From: GILLIAN MARTLEW [REDACTED]
Sent: 24 April 2022 18:51
To: Kathryn Welch <Kathryn.Welch@arun.gov.uk>
Subject: M/20/22/HH

Dear Kathryn
Planning Application:
48 Lane End Road, Middleton On Sea, PO22 6LT

client	project	drawing	date	drawn	drawing no	revision
Jane Cutts	Extension at: 48 Lane End Road Middleton-On-Sea, PO22 6LT	Proposed elevations	Oct 21	pd	0358 / 102	D
			scale 1:100 @ A3	CAD file name:

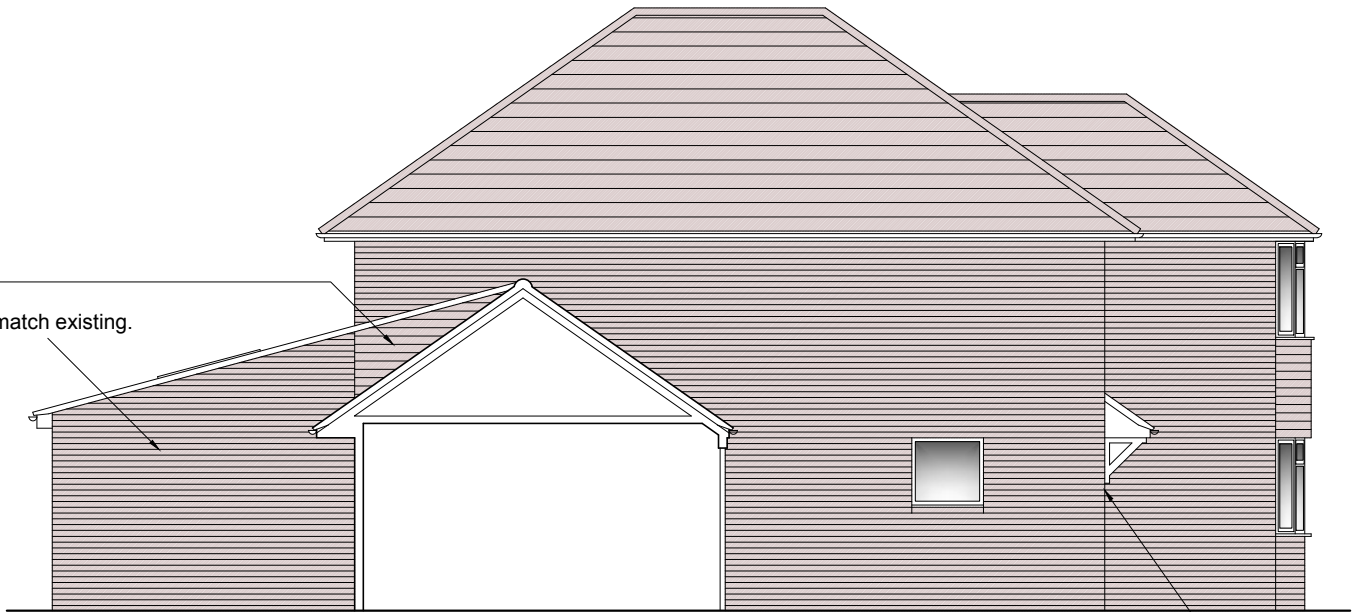
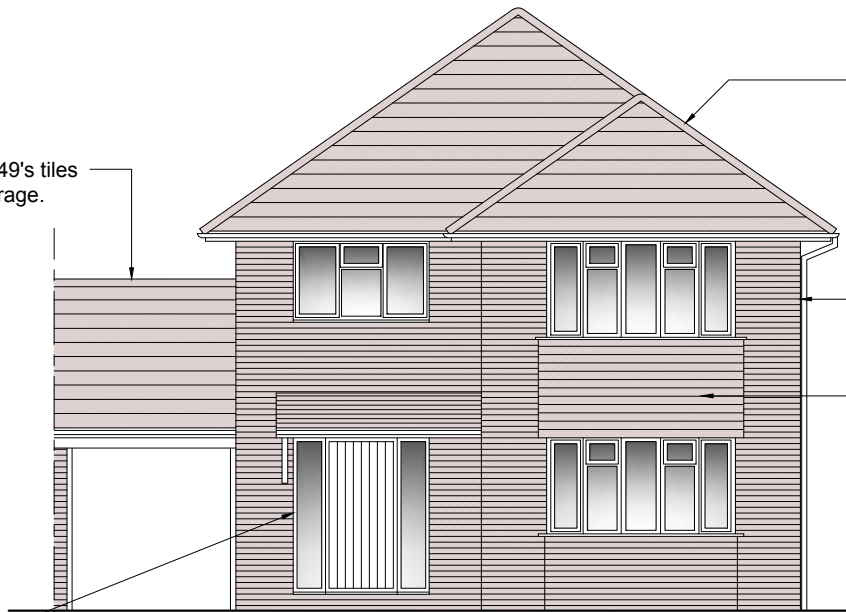
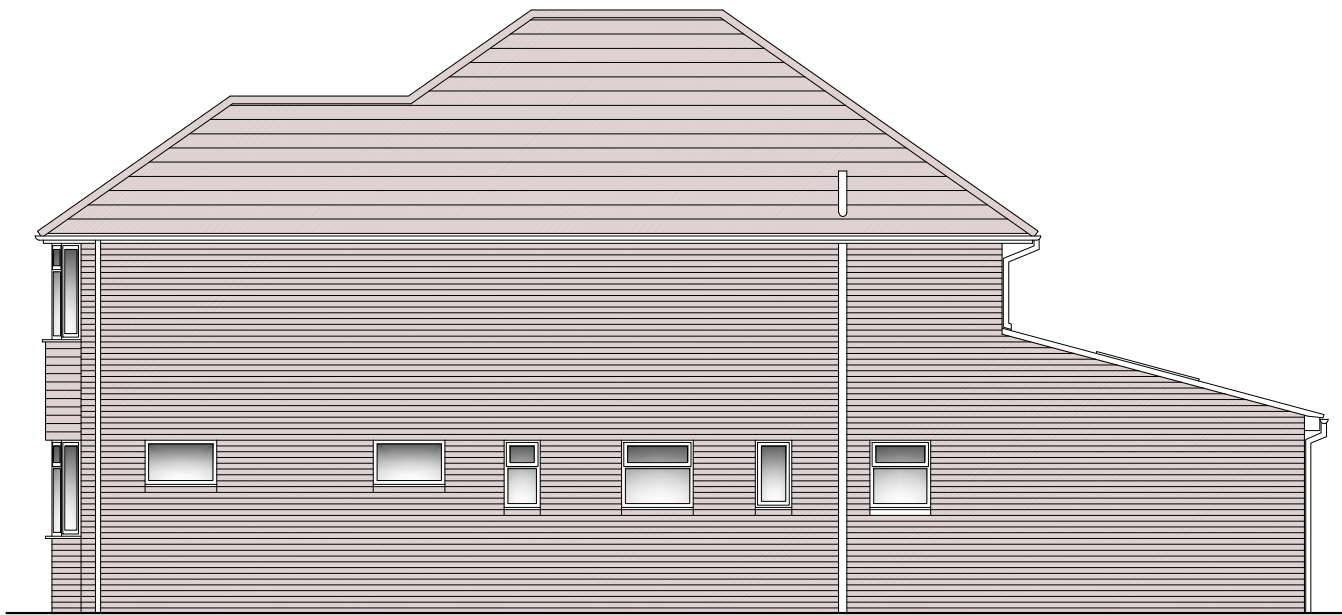
I understand that even for prior approval the external appearance of the extended building, particularly the front elevation, will need to meet the planning authority's demands. This development will be different in appearance from all other buildings in the road.

Despite the applicant's ascertains otherwise, as the immediate neighbour on the north side with an east facing back garden the light and sunlight that we currently enjoy will *definitely* be impacted by the addition of a second storey and the raising of the roof line. It will also overshadow our only south facing window.
